**BP#2016-01901 49 Hancock Street**

Please review the attached revision per your comments.

Summary:

**1.0**

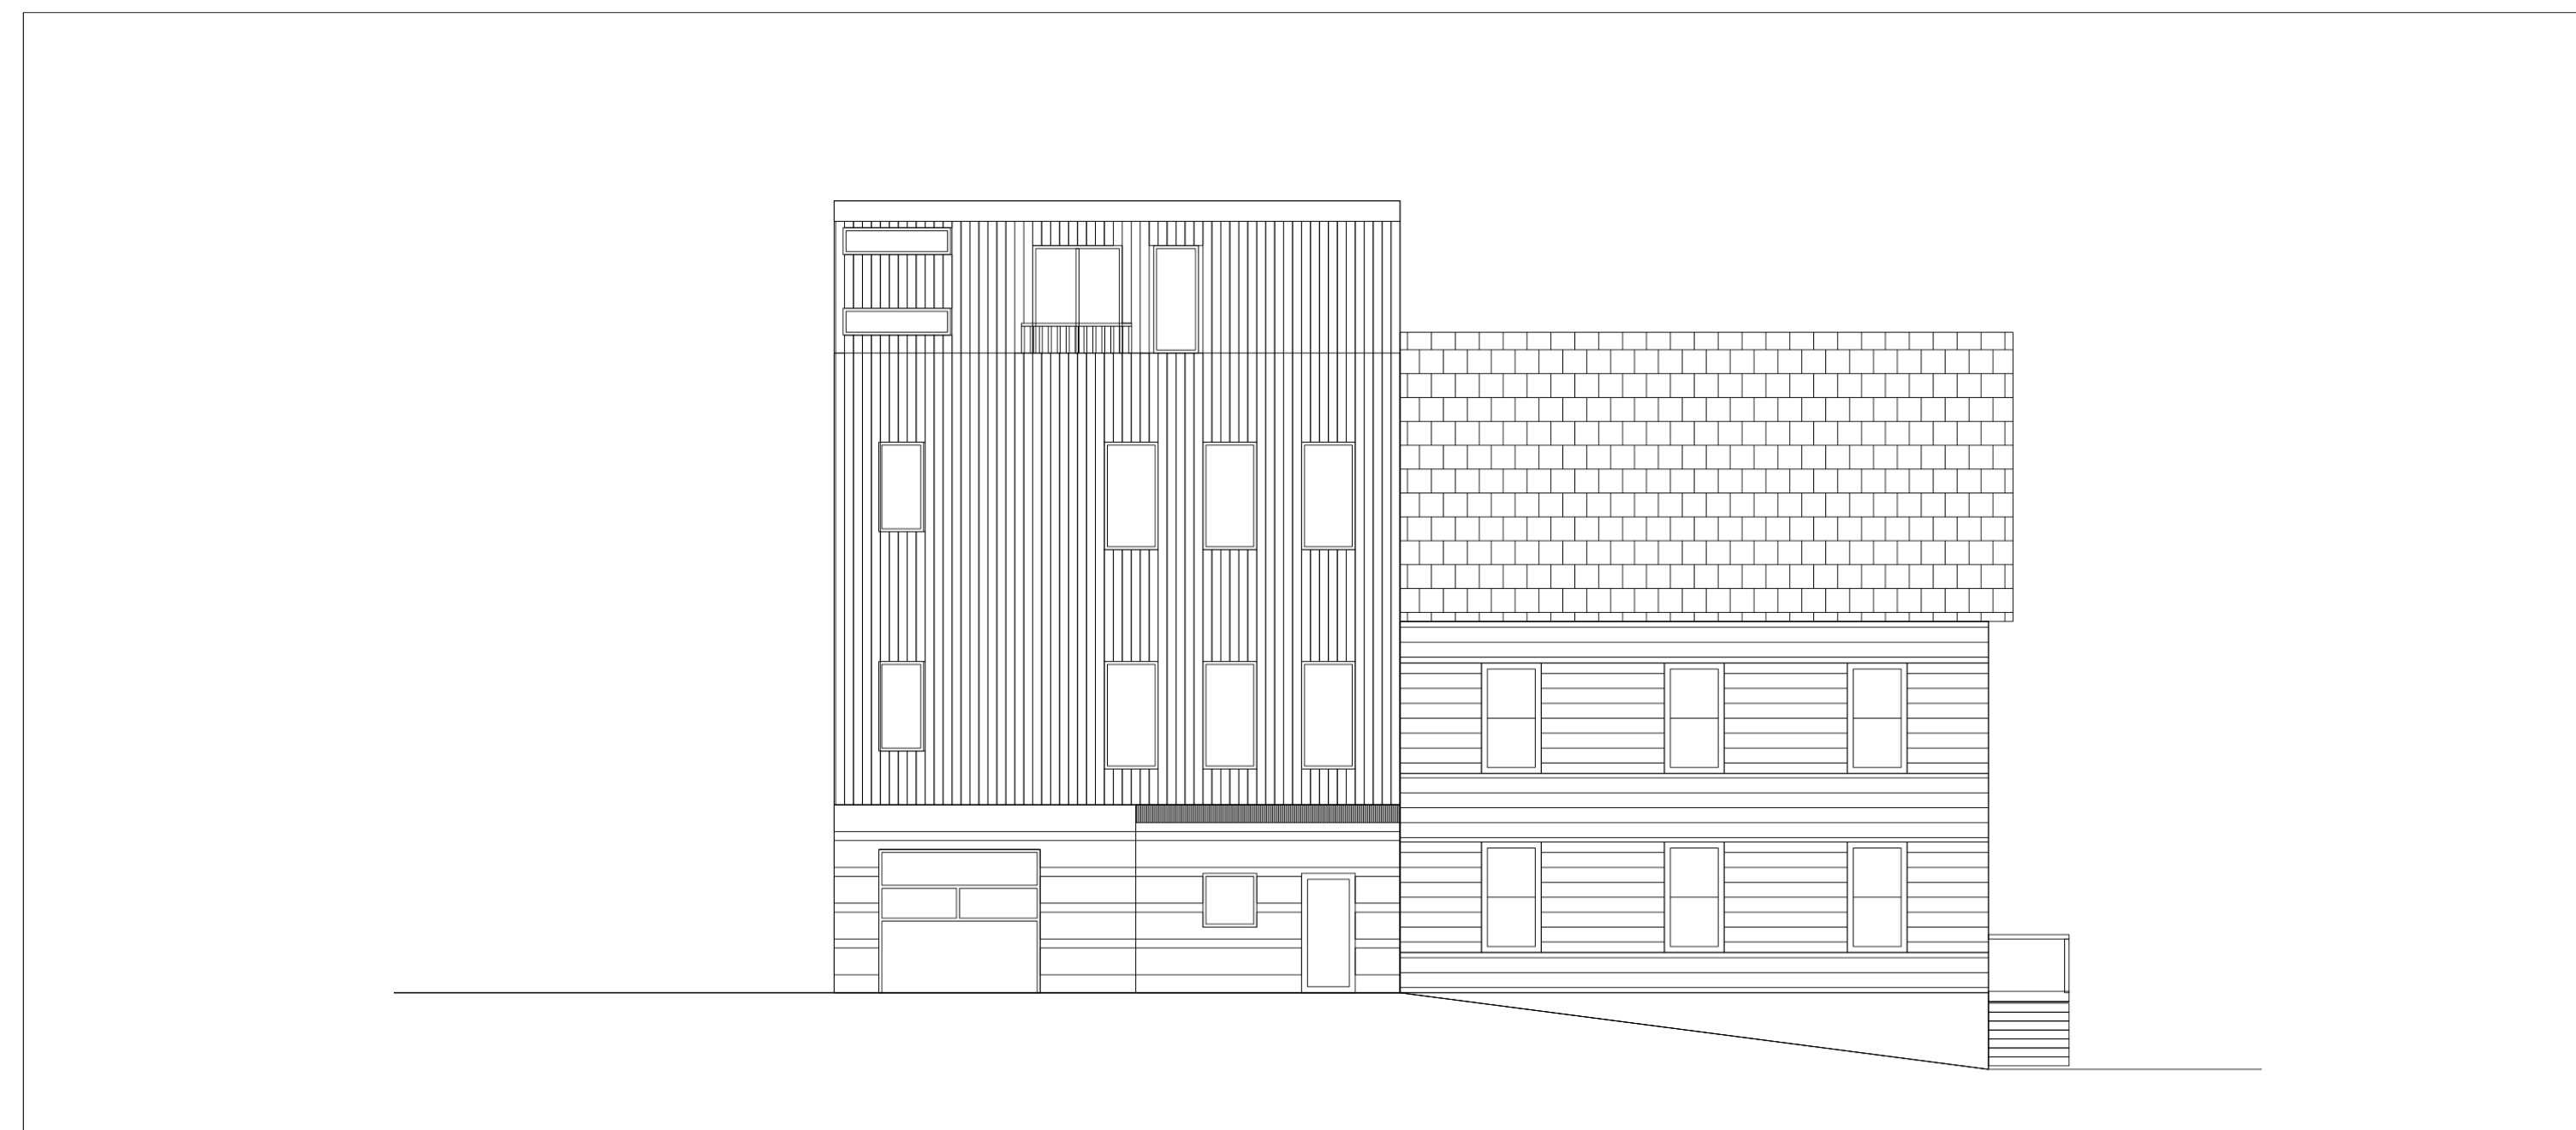
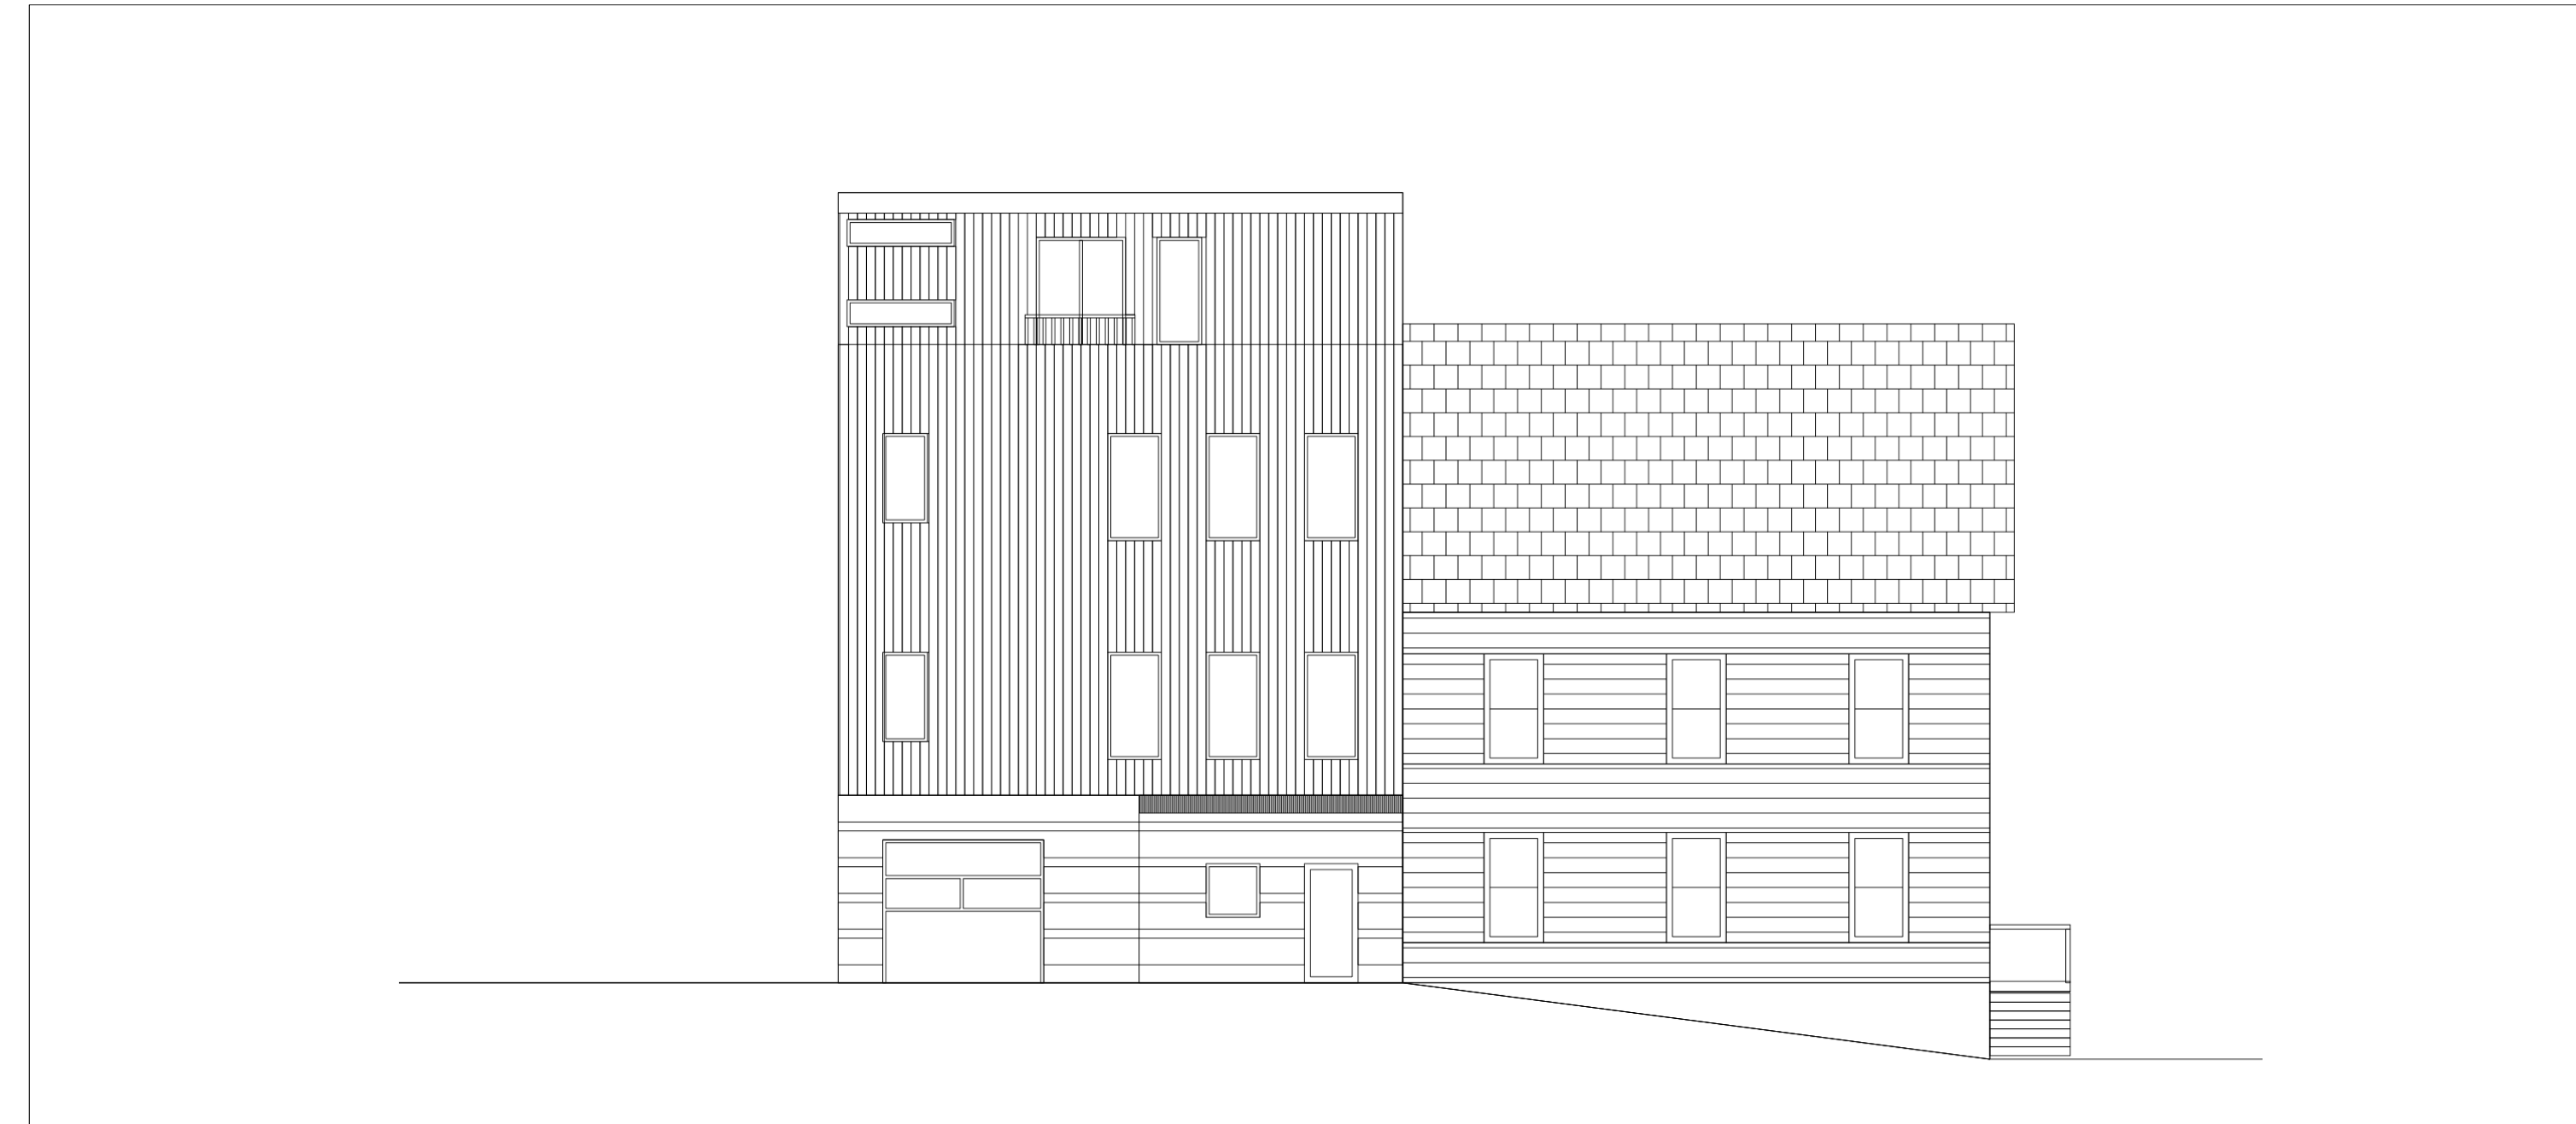
1. 1.0 Cover Sheet: Occupant load number rounded up.
2. A1.1 "Flame OFF" cut sheet attached with this email. The cut sheet shows fire rating with the paint thickness needed to apply.
